# THE RESERVE AT CORRAL BLUFFS SUBDIVISION FILING NO. 3 Construction Drawings El Paso County, Colorado

THE RESERVE AT CORRAL BLUFFS SUBDIVISION FIL NO. 3

SHEET: C1

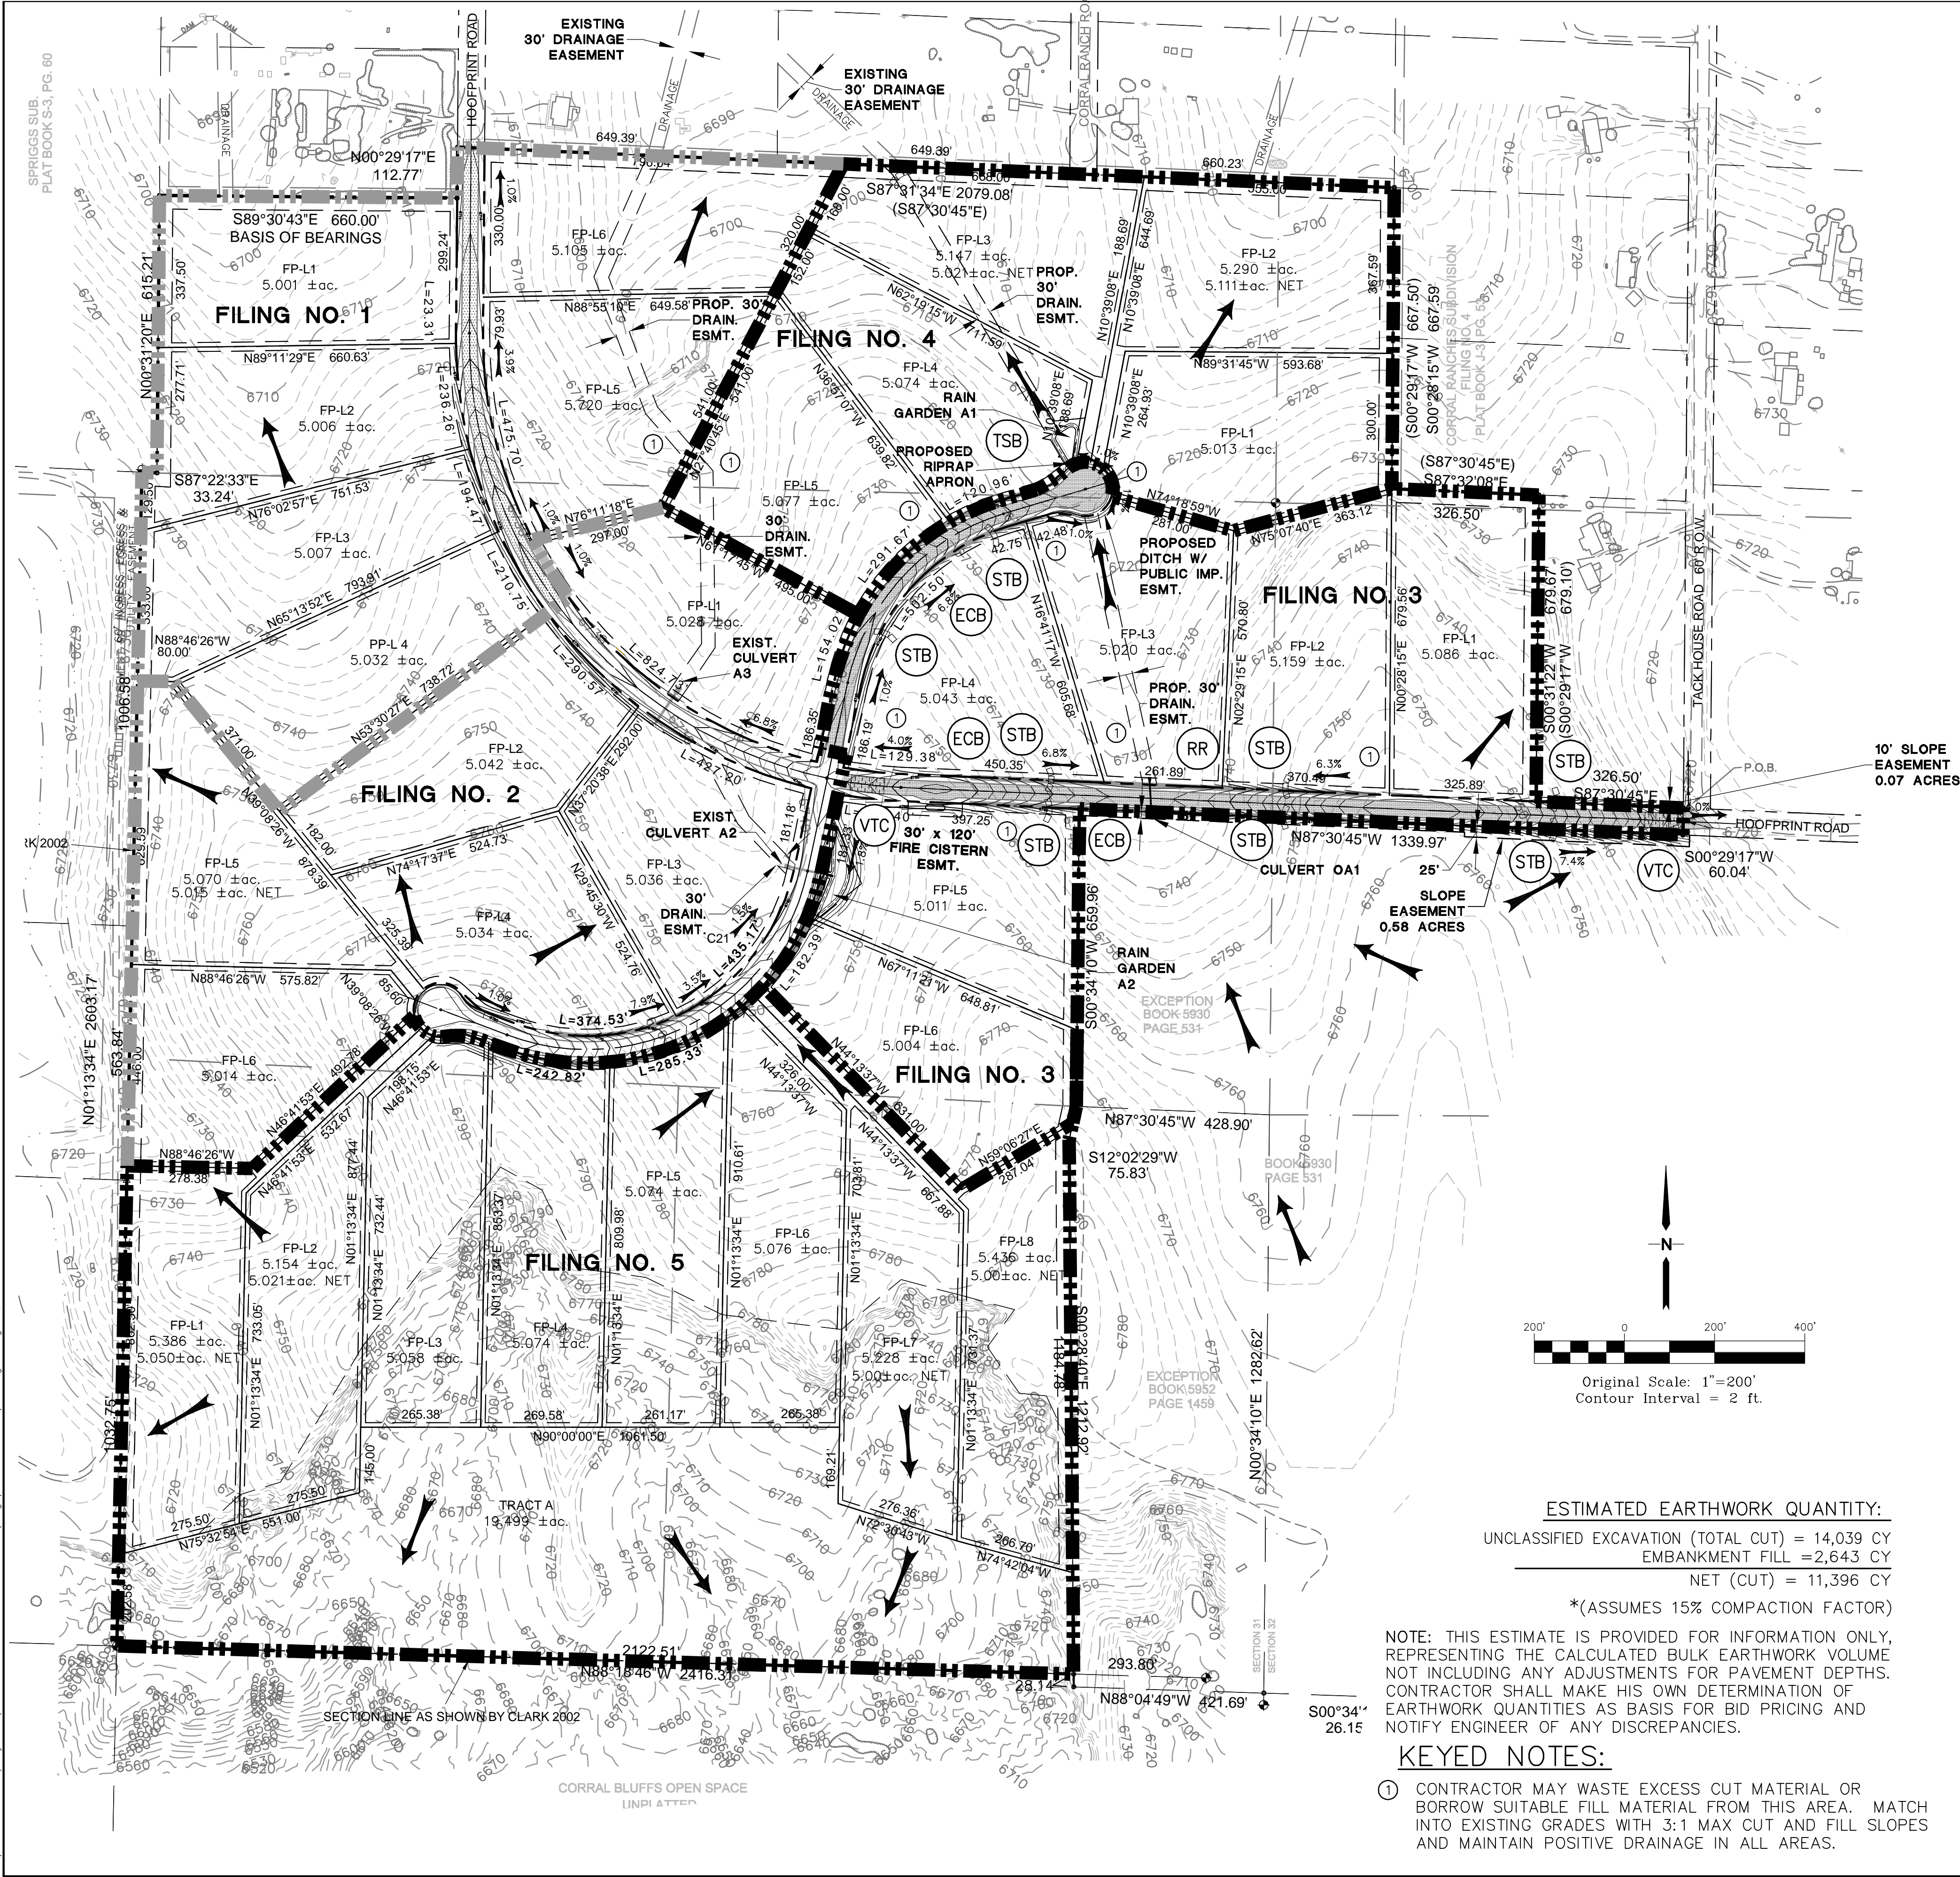
The plan view indicates that this is an existing culvert. Revise accordingly.
